17 May 2012

(Your Ref: MP10_0177 MOD 9)

**RE: COUNCIL SUBMISSION TO MP10_0177 MOD 9, AMENDED APPLICATION FOR
MODIFICATION OF MAJOR PROJECT APPROVAL UNDER SECTION 75W**

BUILDING E PLANS & ELEVATIONS
SCALE 1:200

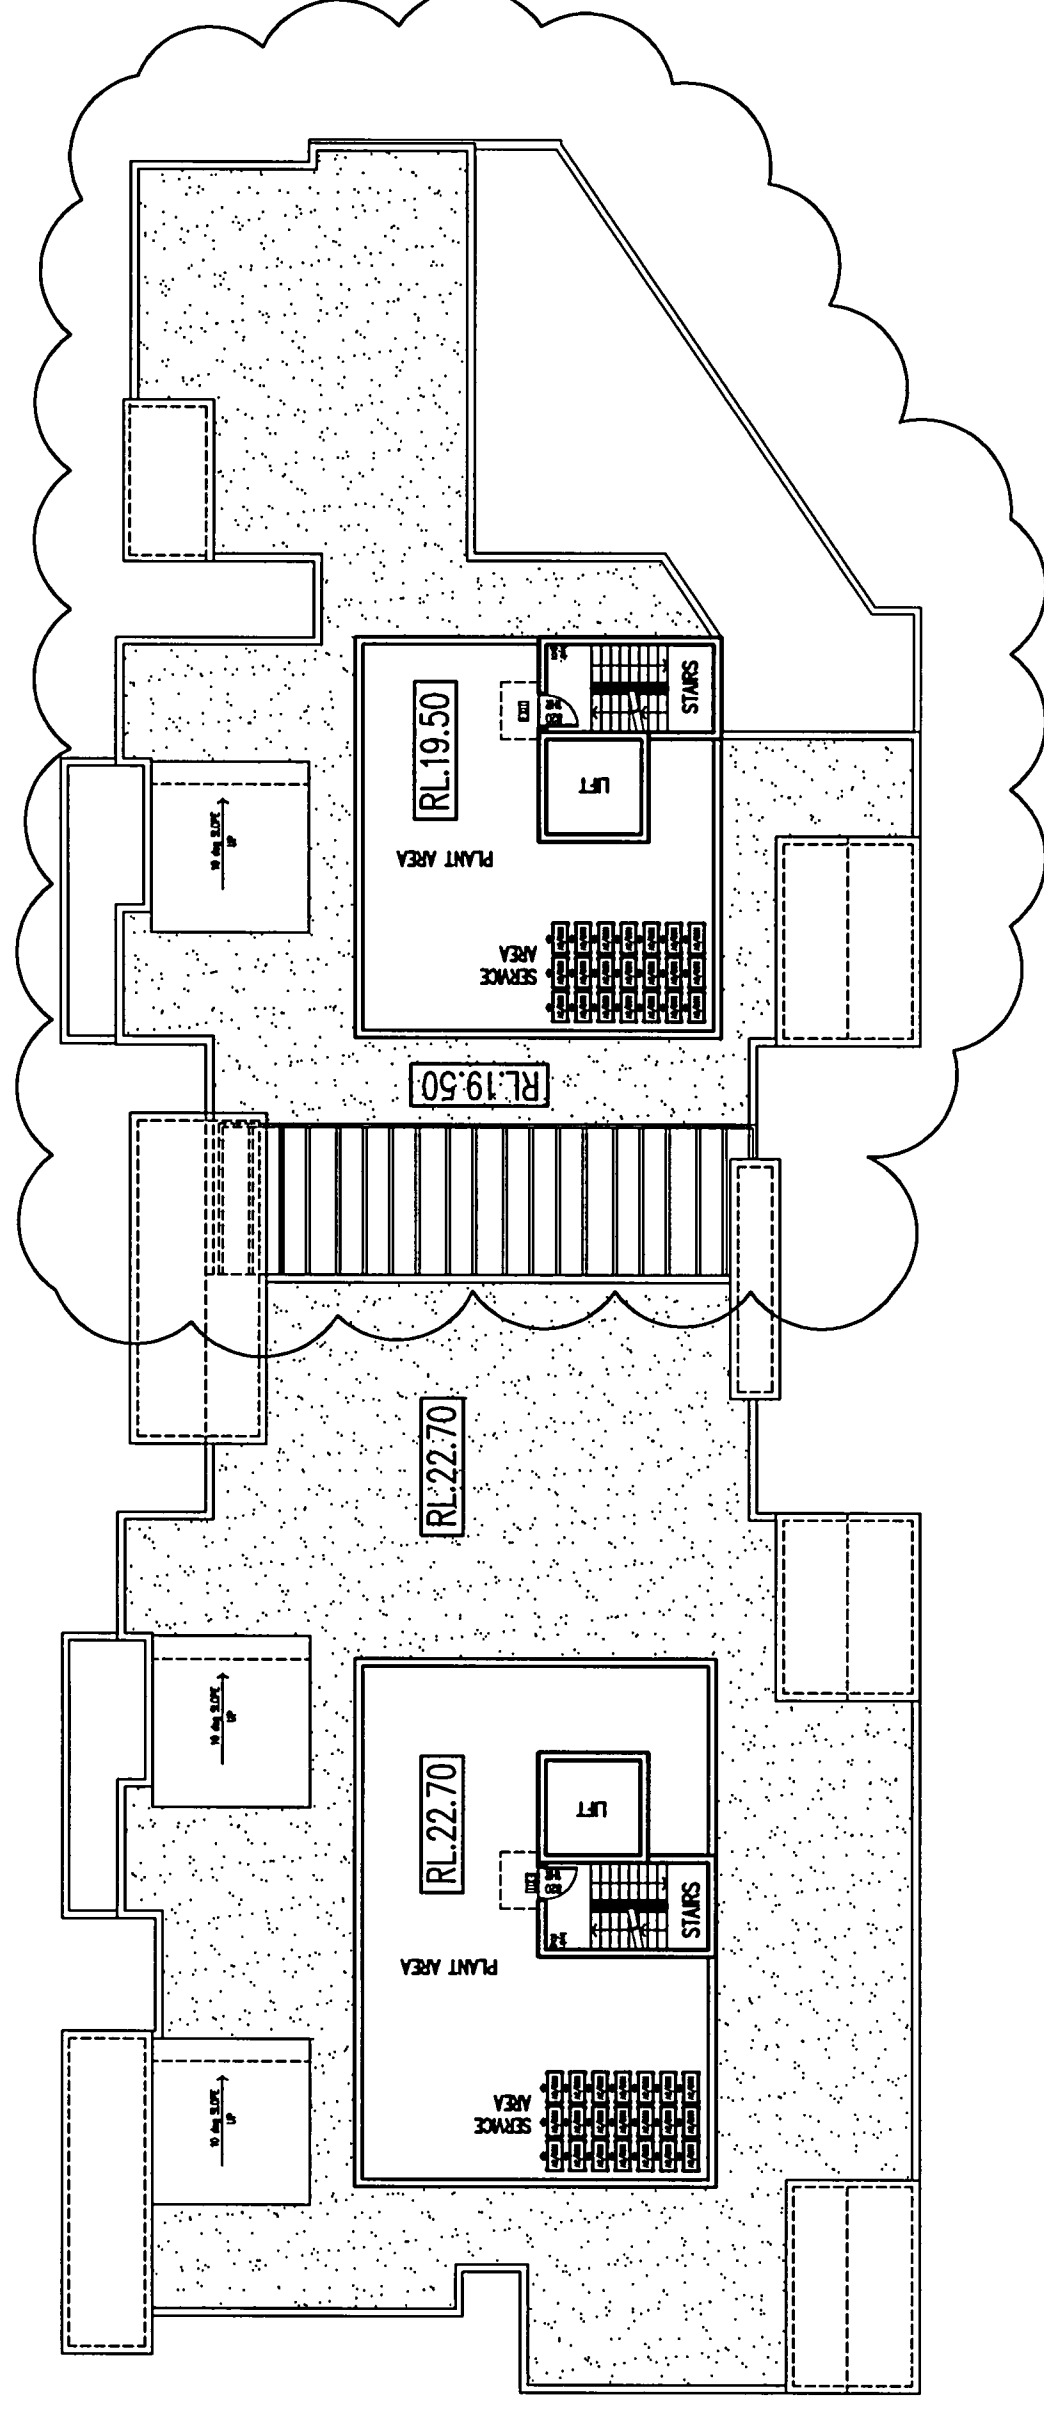
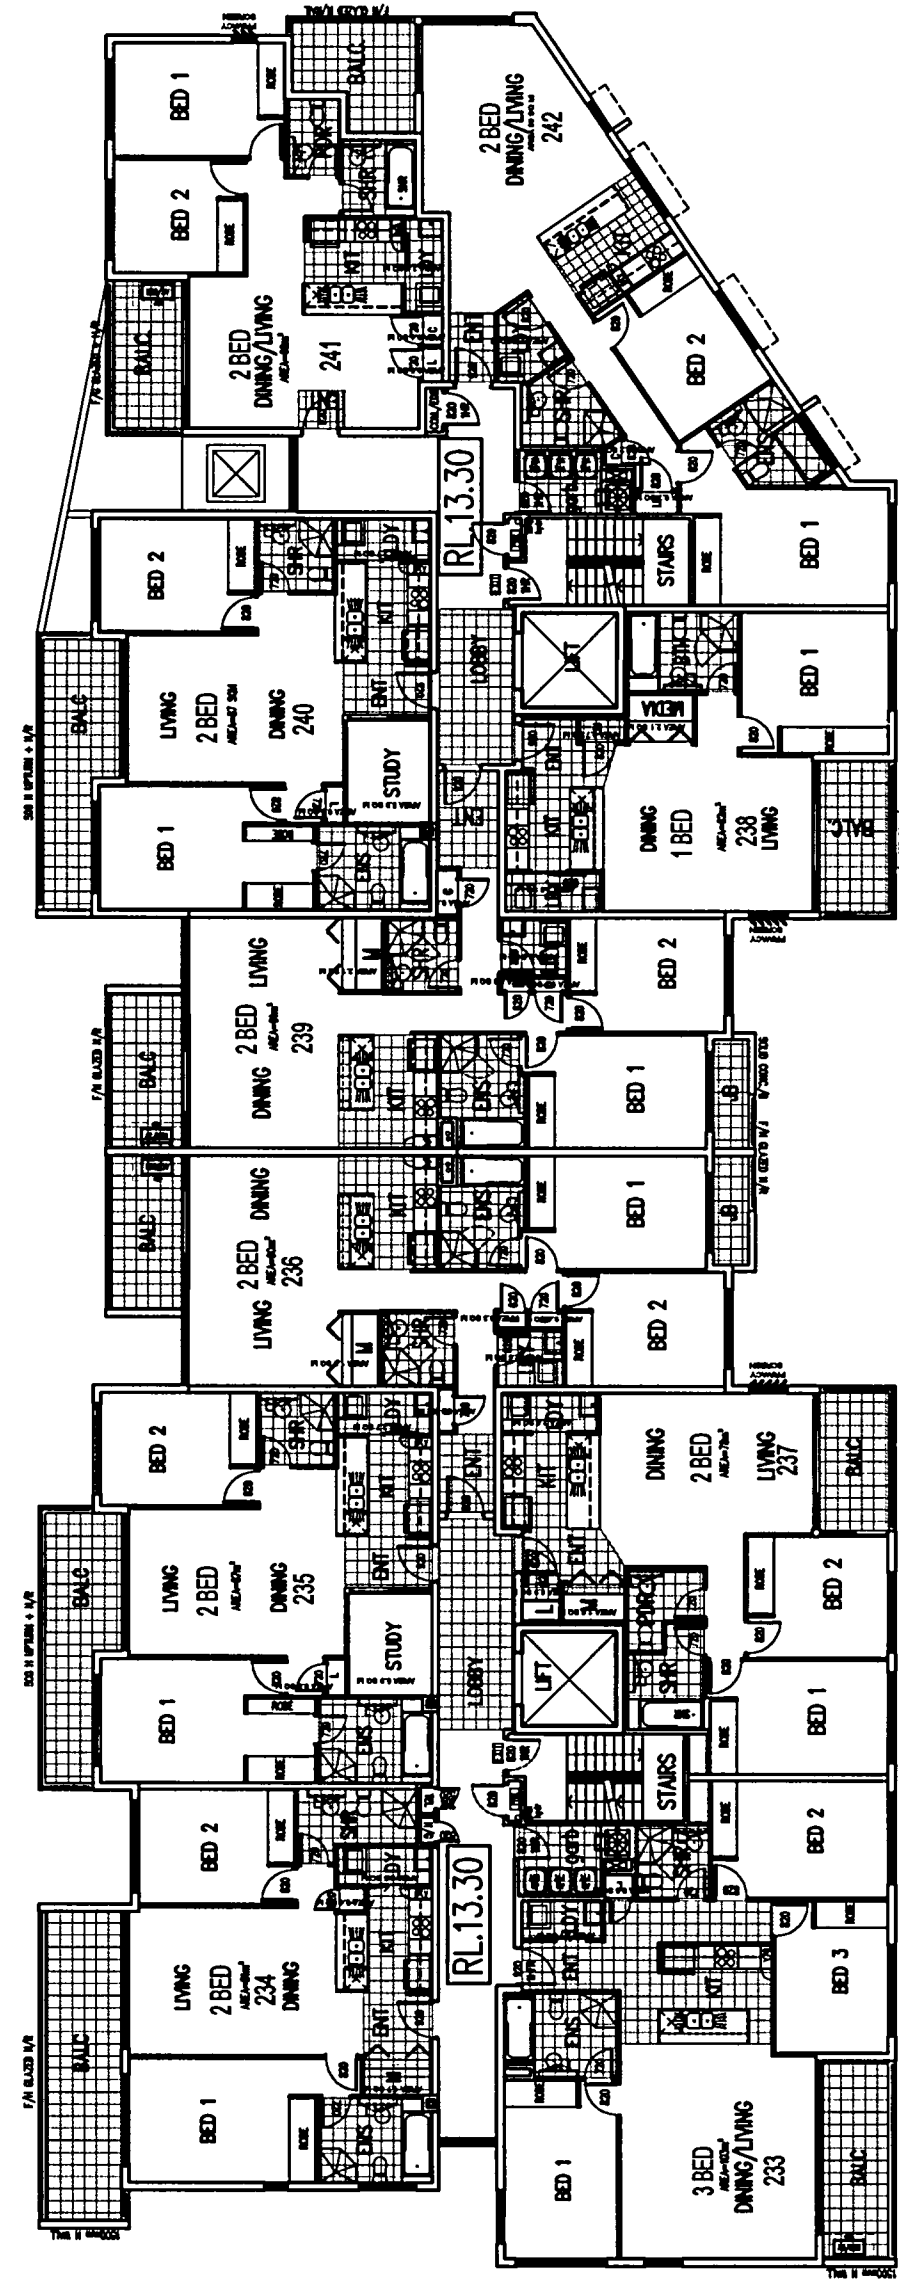
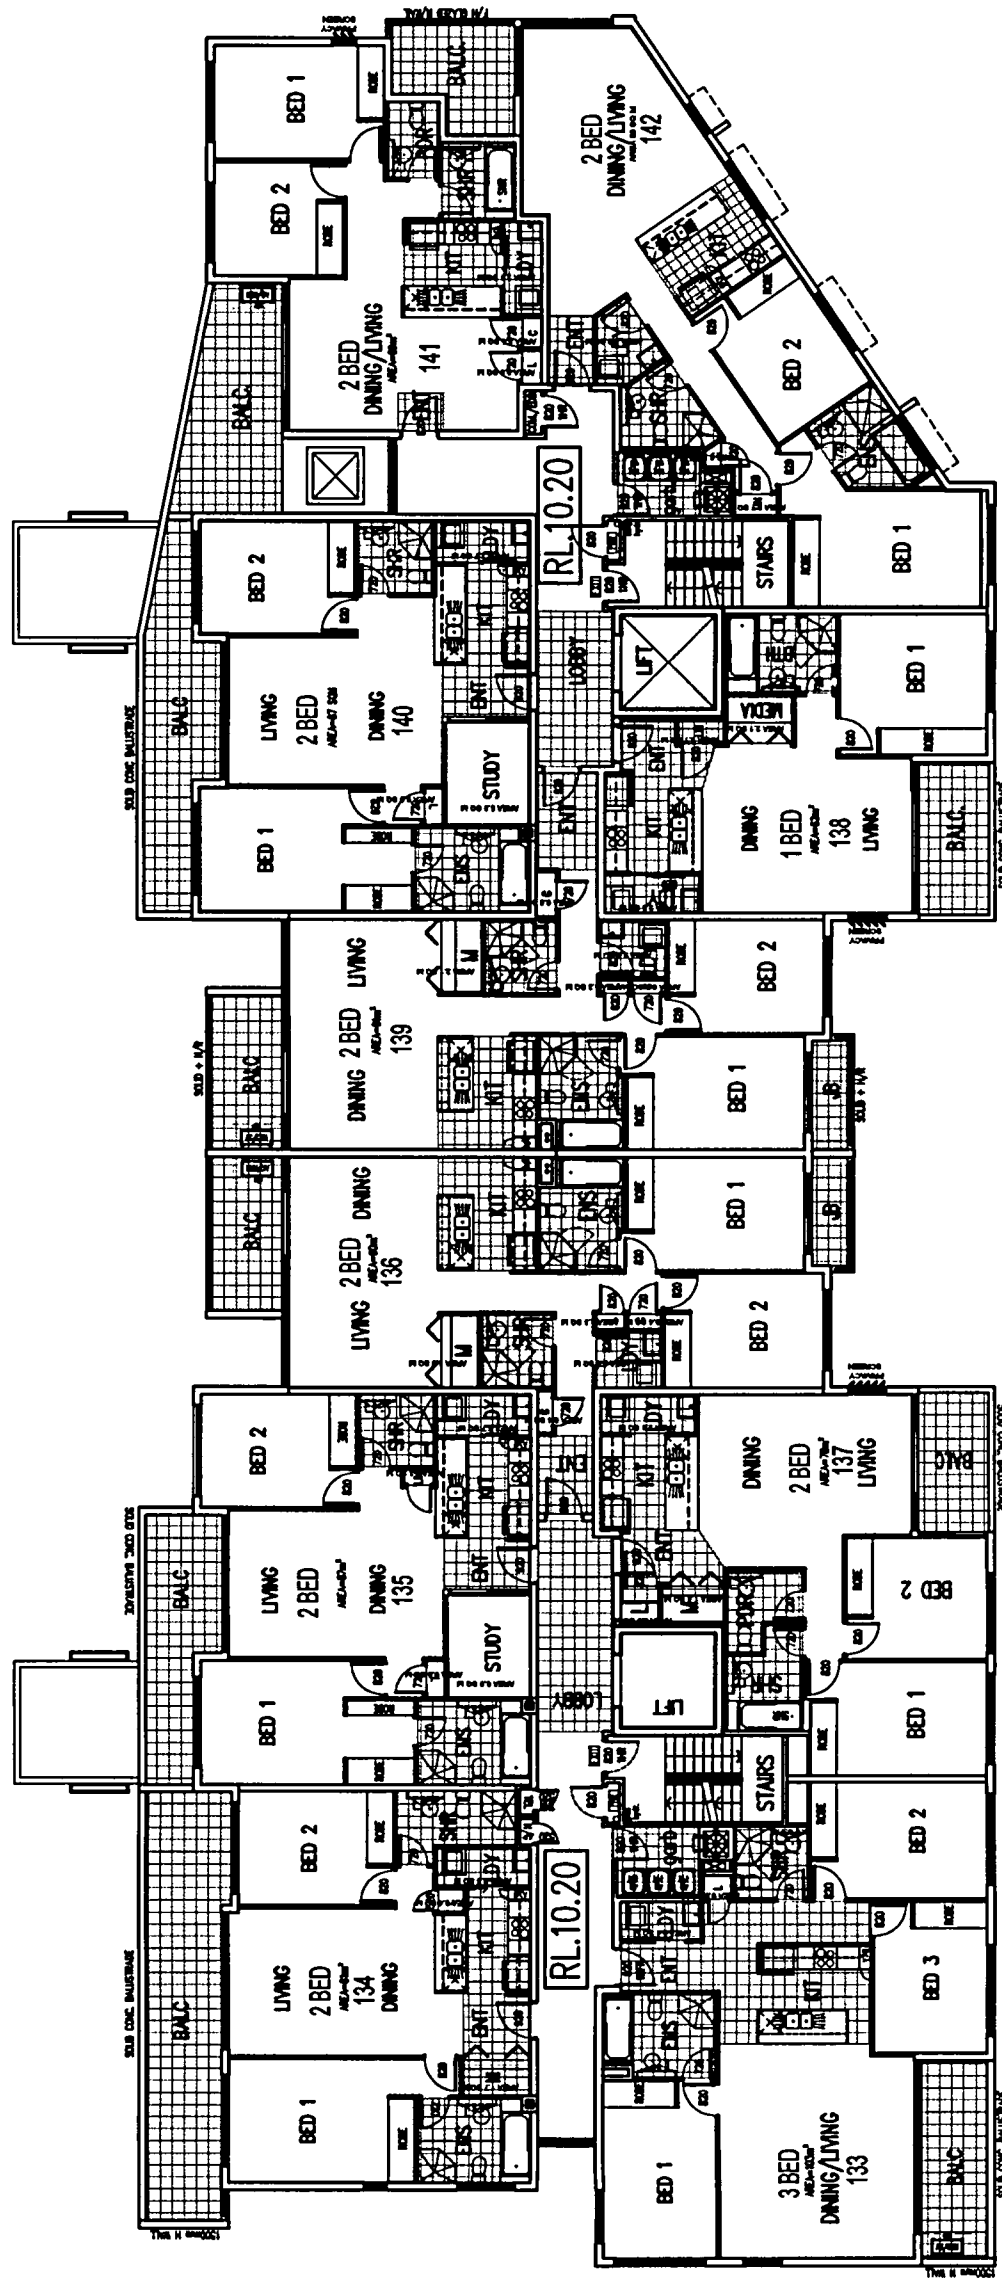
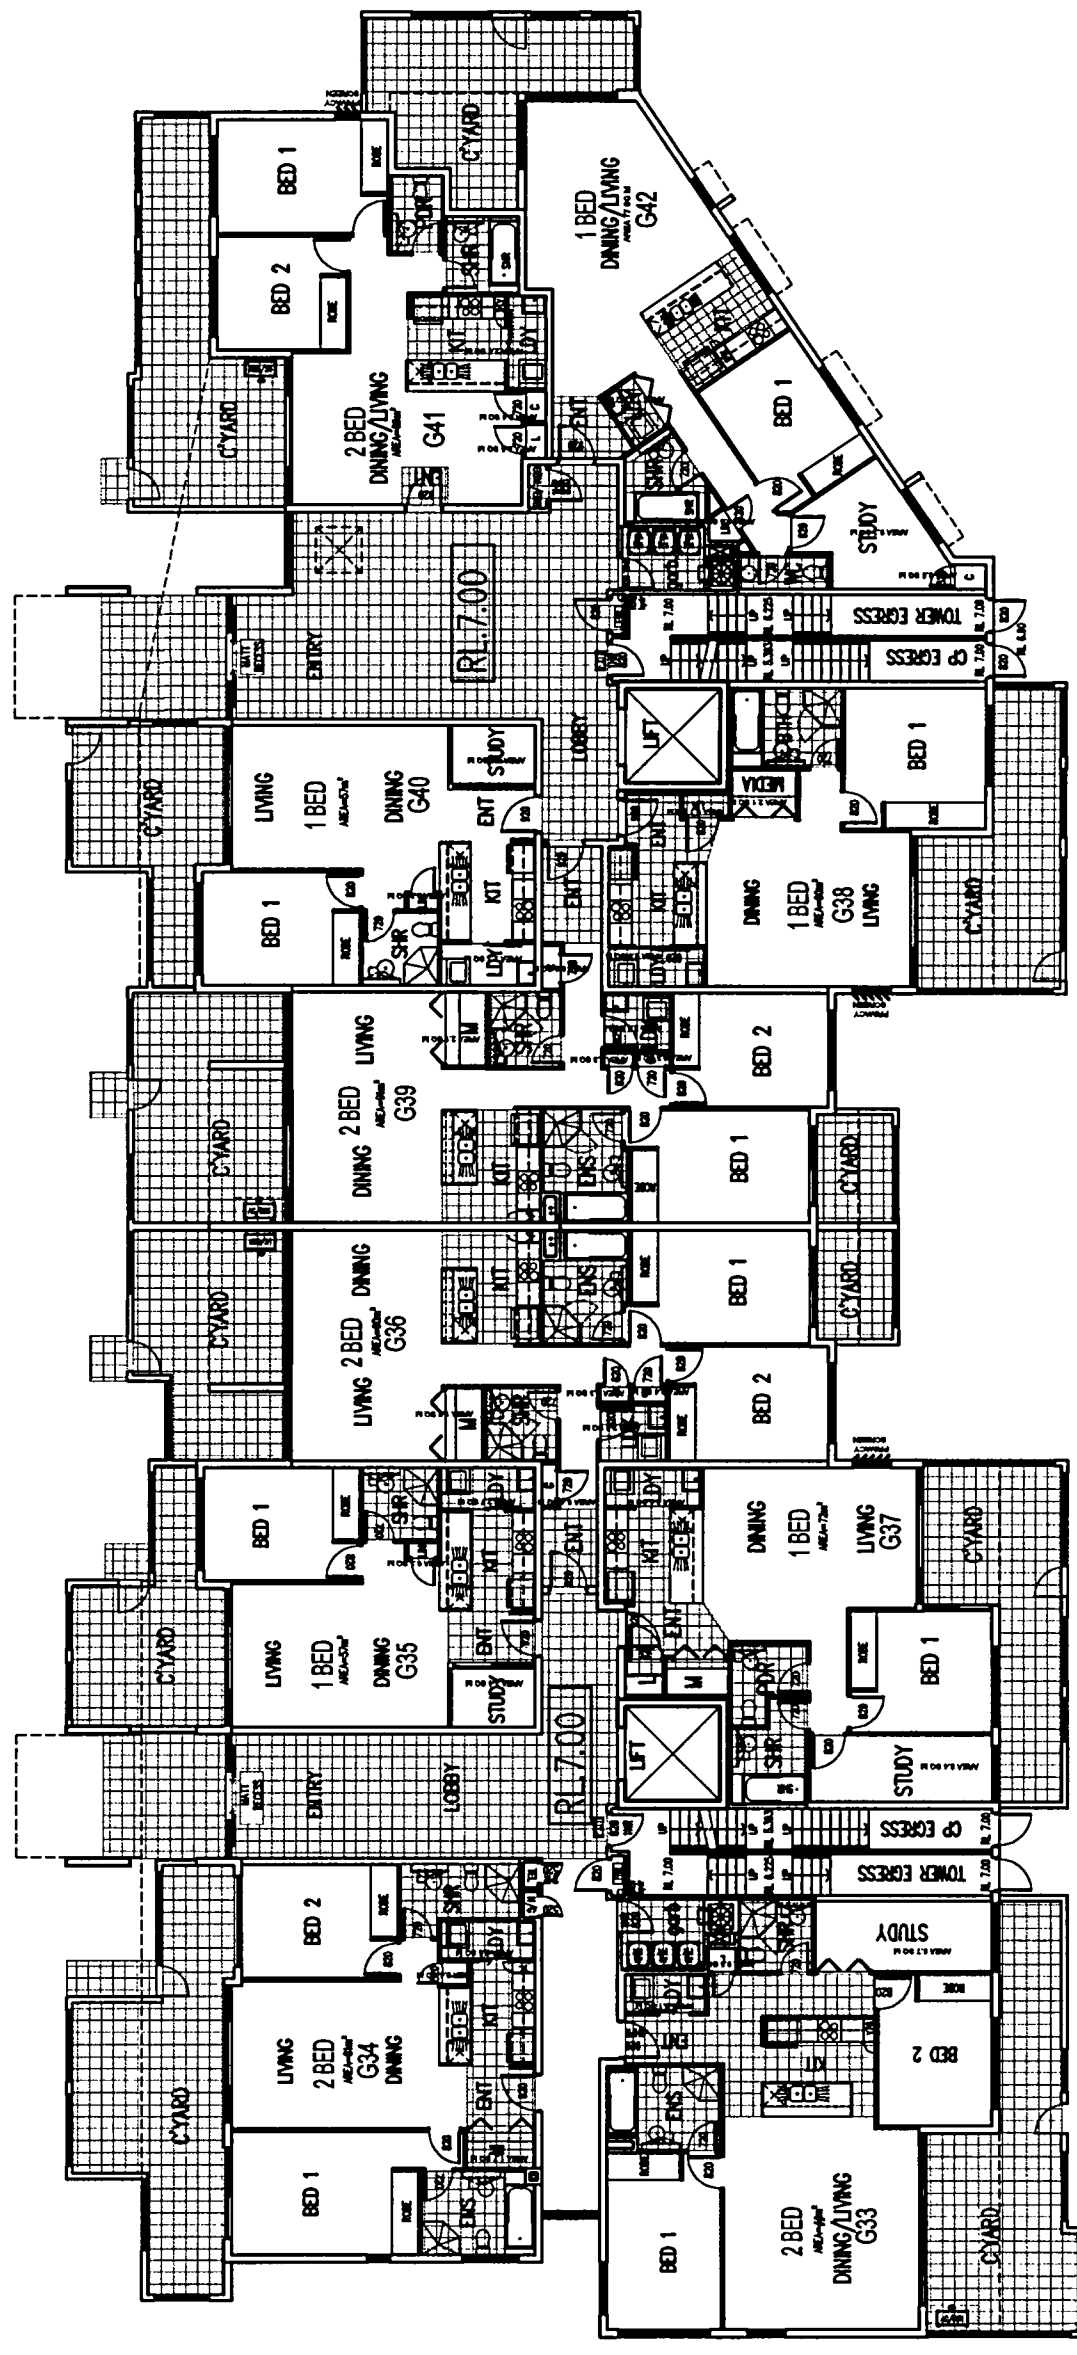
- The addition of separate studies to units 361, 361, G37, 236, 234, 136, 134, 330 and 335;
- Small adjustments to the layout of some units to accommodate the proposed studies. This consists of the relocation or realigning of kitchens, the relocation of the laundries and storage cupboards, and a revision of the window and door openings;
- The addition of two 'pop up' rooves above units 361 and 363;
- Insert a large storage cupboard into unit G34;
- Extend the cement slab that is at the roof level over the balcony of unit 330 to provide a roof for the balcony; and
- Alter the south facing windows in unit 331.

1. will not result in the study areas able to converted into additional bedrooms that in turn requires additional car parking spaces, and
2. in accordance with the BASIX Certification.
